Your Ref: OWQC24954
Our Ref: BR/233/19/PL
Please ask for:
Mr S Davis

Part change of use of ground floor & formation of a first floor rear extension to create 2
No self-contained studio flats with associated refuse/ recycling & cycle store
(resubmission following BR/63/18/PL).

77 Aldwick Road Bognor Regis

REAR
PROPOSED ELEVATIONS
Scale 1:100

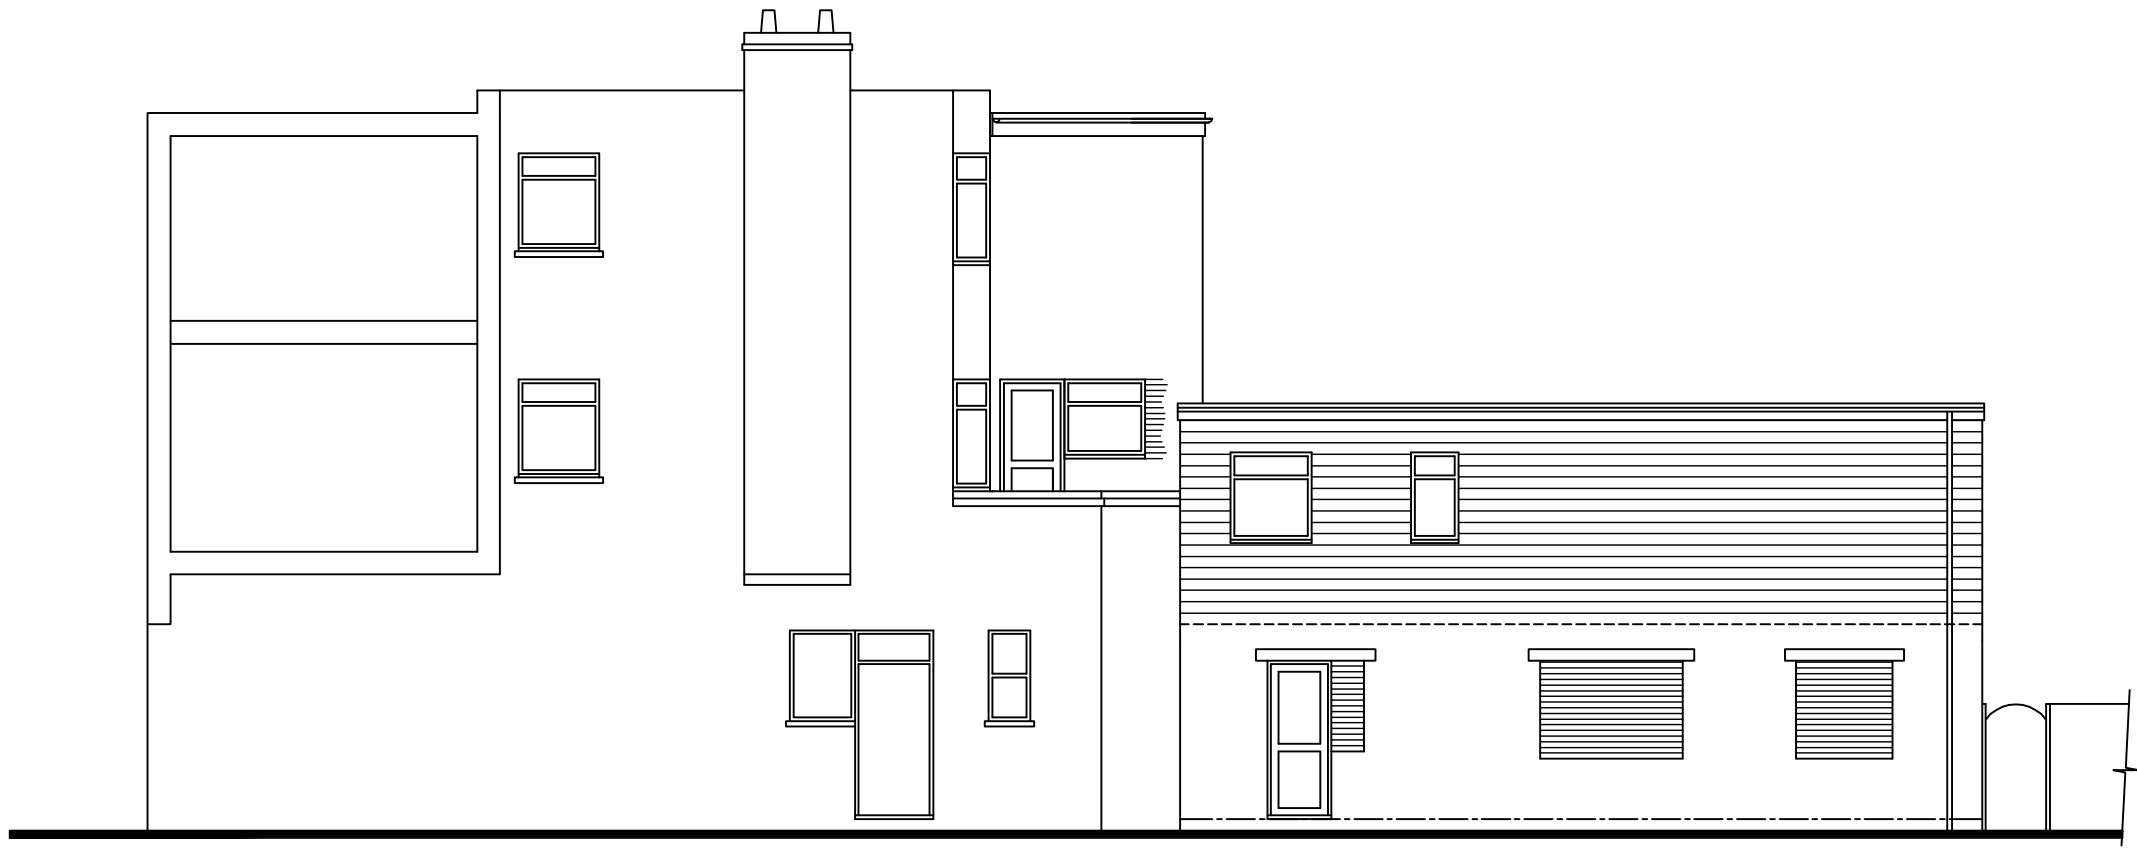
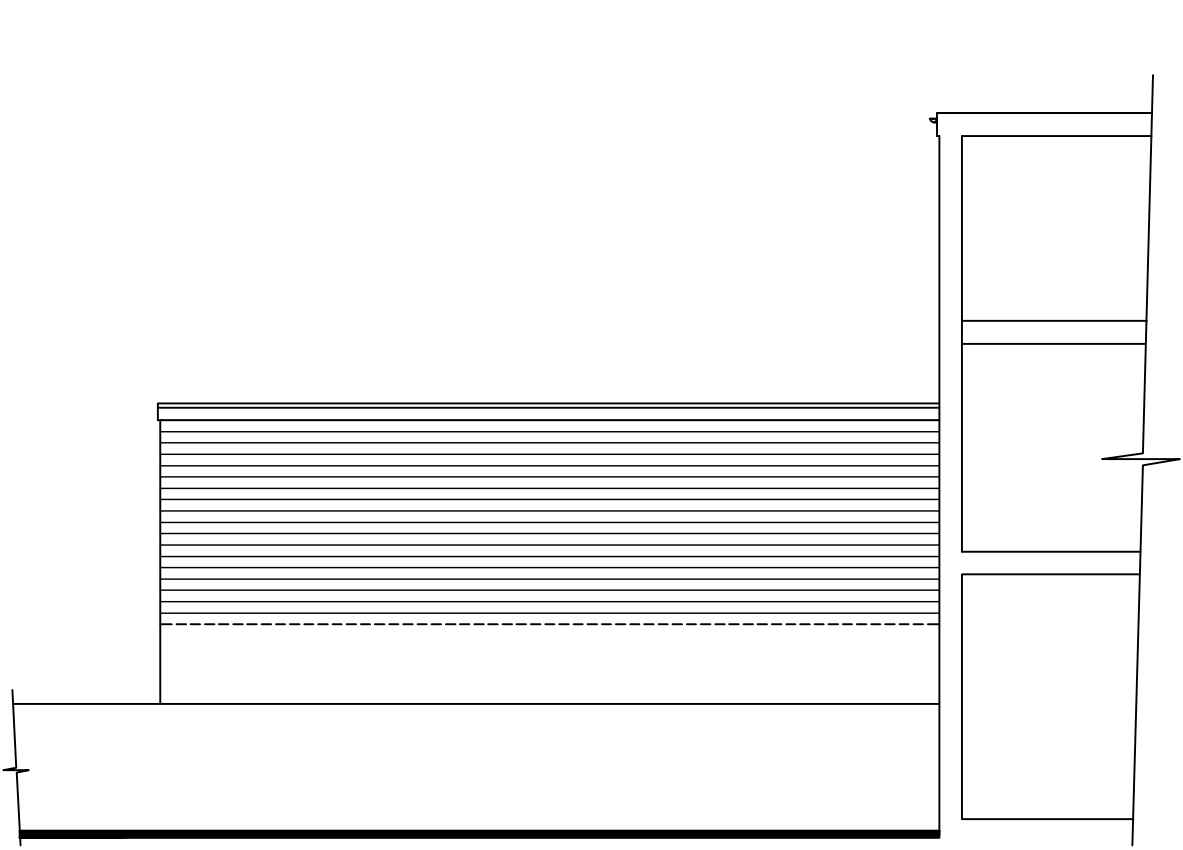
OBJECTION The scale of the proposed first-floor extension to the rear of 77 Aldwick Road will result in an overbearing impact on - and loss of outlook to - the amenity of the existing windows of residential flats in the rear of 73-75 Aldwick Road to the east and 79 Aldwick Road to the west. In addition, there will be a harmful loss of sunlight and overshadowing of the two large residential windows on the closest part of the rear of 79. The proposal is therefore contrary to policy GEN7 of the Arun District Local Plan; the National Planning Policy Framework; and policies DDM1 & DDM4 of the Arun Local Plan 2011-2031.

The new first floor studio windows will look out towards the rears of Nos. 10 & 14/16 Stocker Road at a distance of only around 8.8m. This will result in a loss of privacy to number 10's private residential garden. The new first floor kitchen, hall and stair windows will face towards the flank residential windows of 79 Aldwick Road, resulting in a loss of privacy to these windows and a harmful effect on the amenity of existing occupiers. The proposal is therefore contrary to policy GEN7 of the Arun District Local Plan; the National Planning Policy Framework; and policies DDM1 & DDM4 of the Arun Local Plan 2011-2031.
